**KIRKLEES METROPOLITAN COUNCIL  
TOWN AND COUNTRY PLANNING ACT 1990  
HIGHWAYS DEVELOPMENT CONTROL KP20H**

**PLANNING REF** 2012/62/92106/E0/SL  
**CATEGORY** Small Major

**PROPOSAL** ERECTION OF SUB-TERRANEAN  
DWELLING AND ASSOCIATED WORKS

**LOCATION** DENBY LANE  
UPPER DENBY  
HUDDERSFIELD  
HD8 8XZ

GENERAL

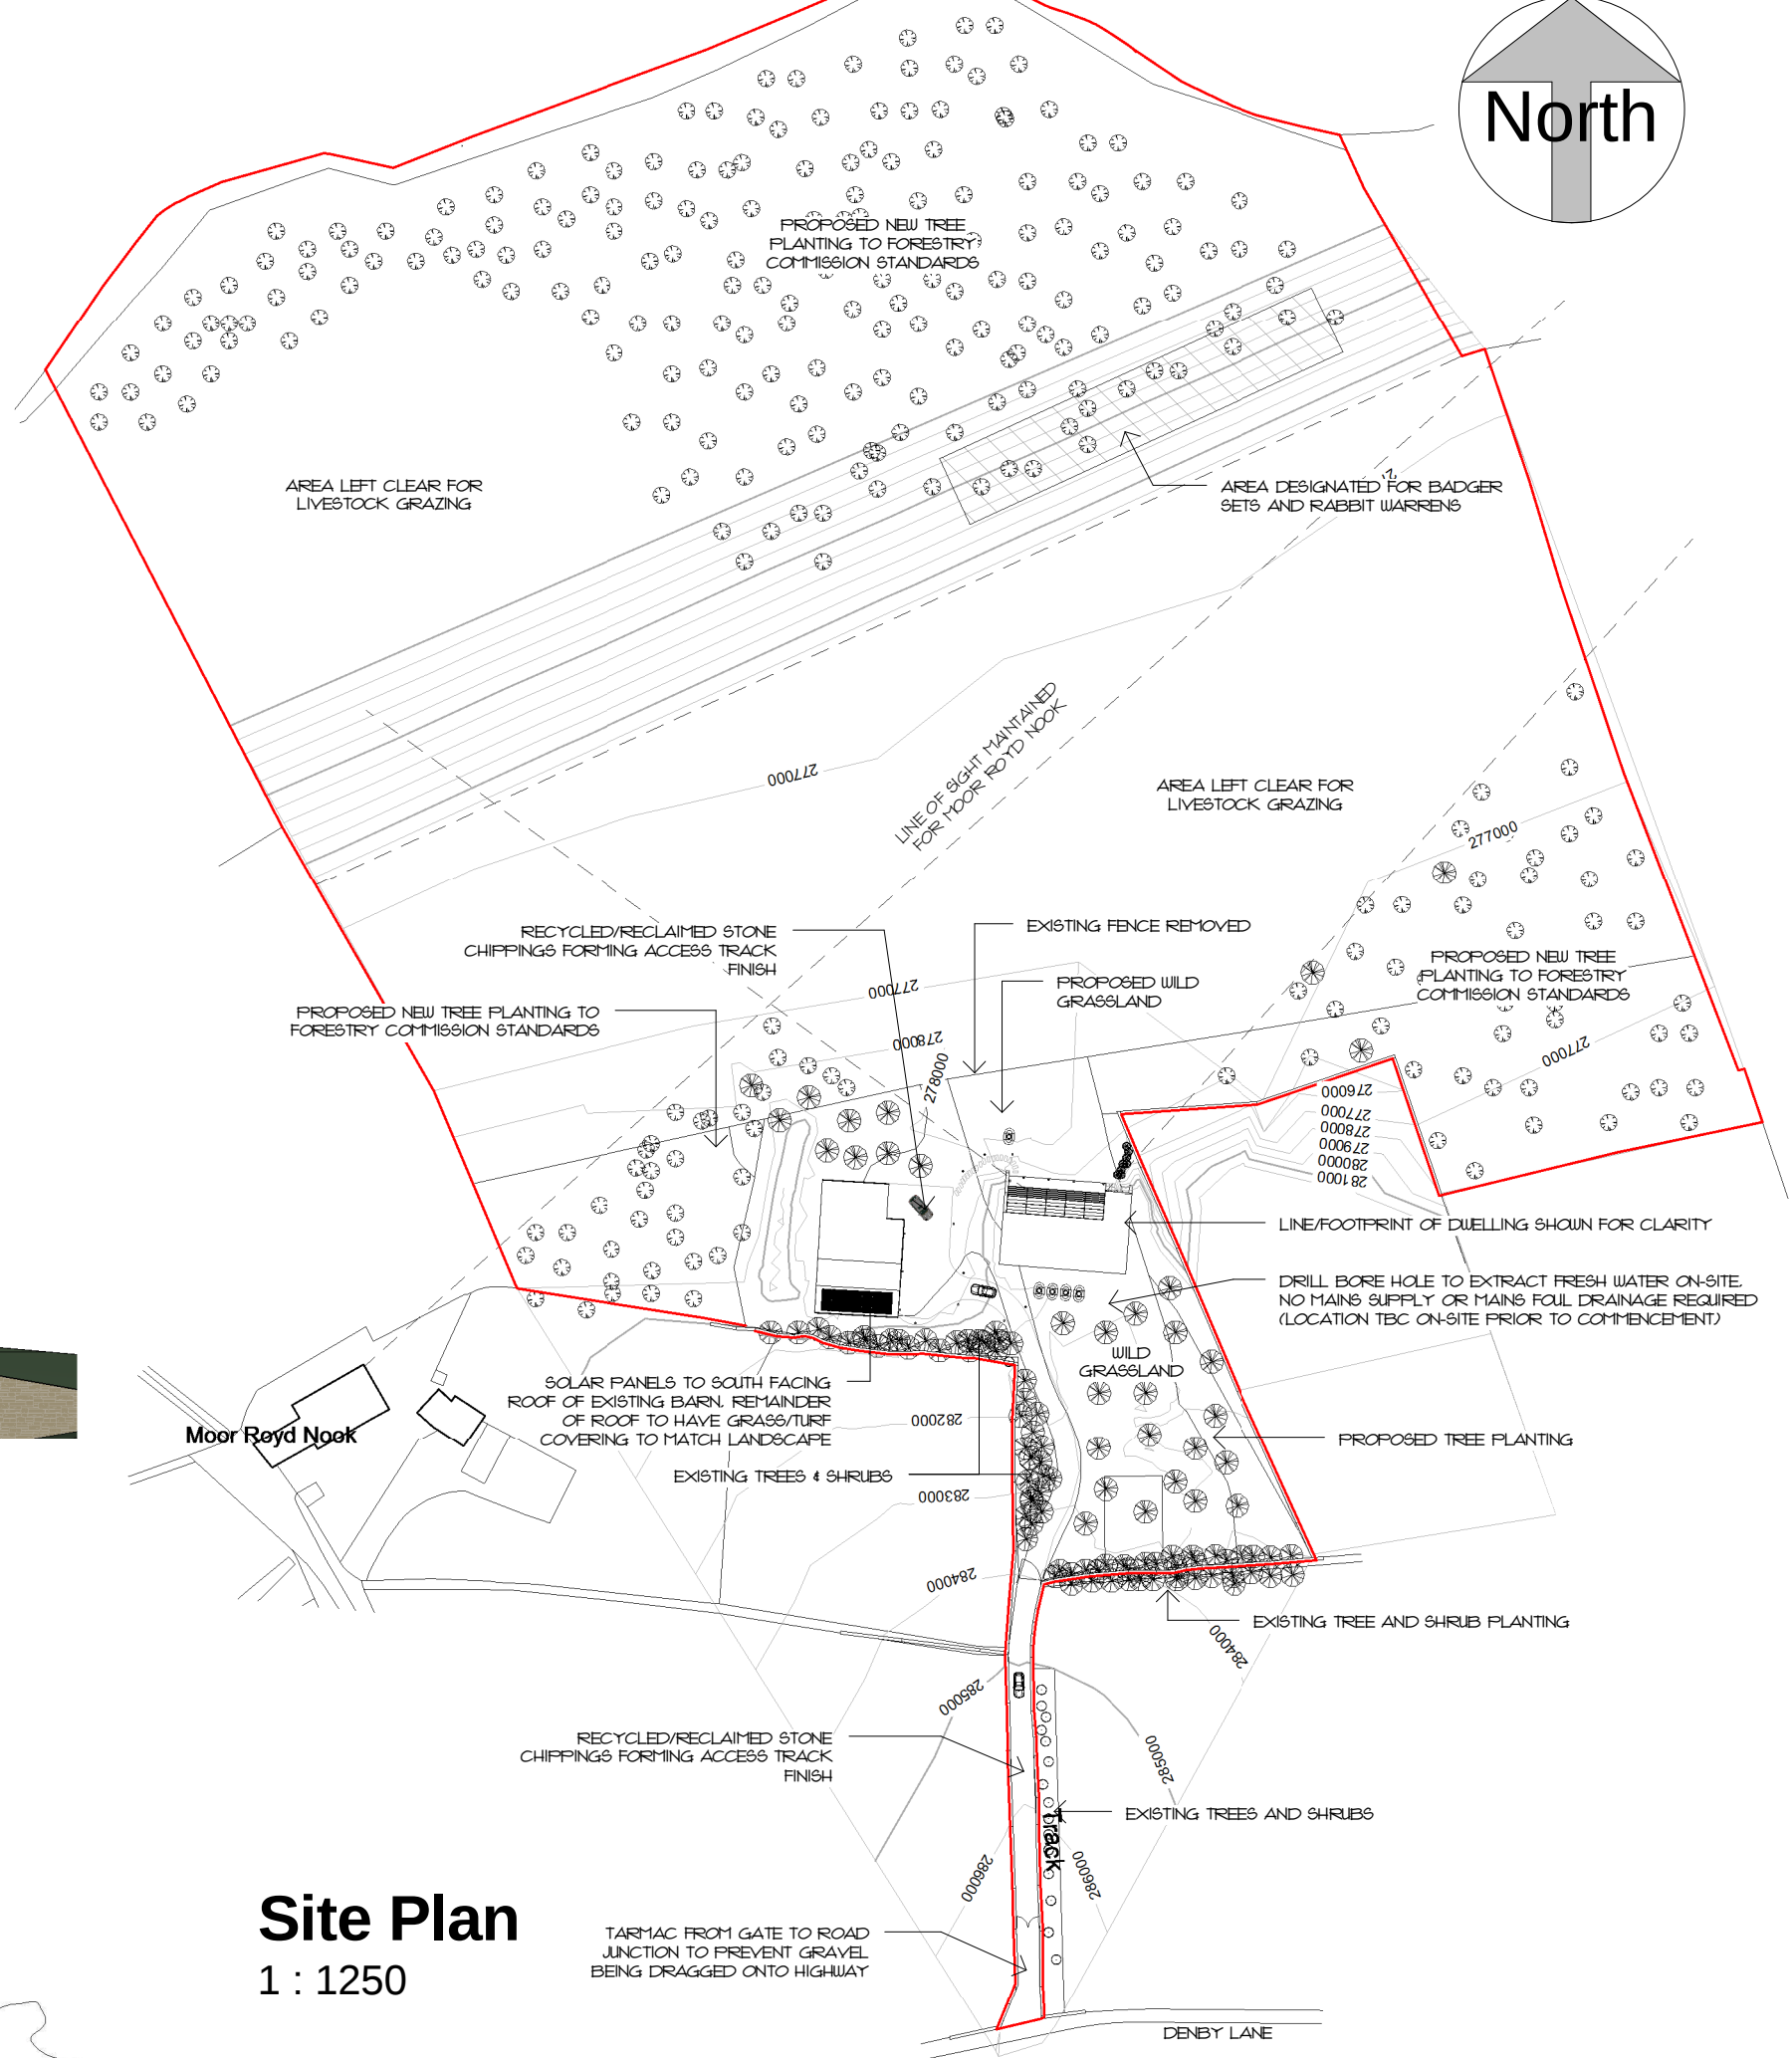
Whilst there is adequate space within the site to accommodate parking and servicing given that the site is in green belt the application needs to identify parking and servicing arrangements together with the curtilage of the dwelling.
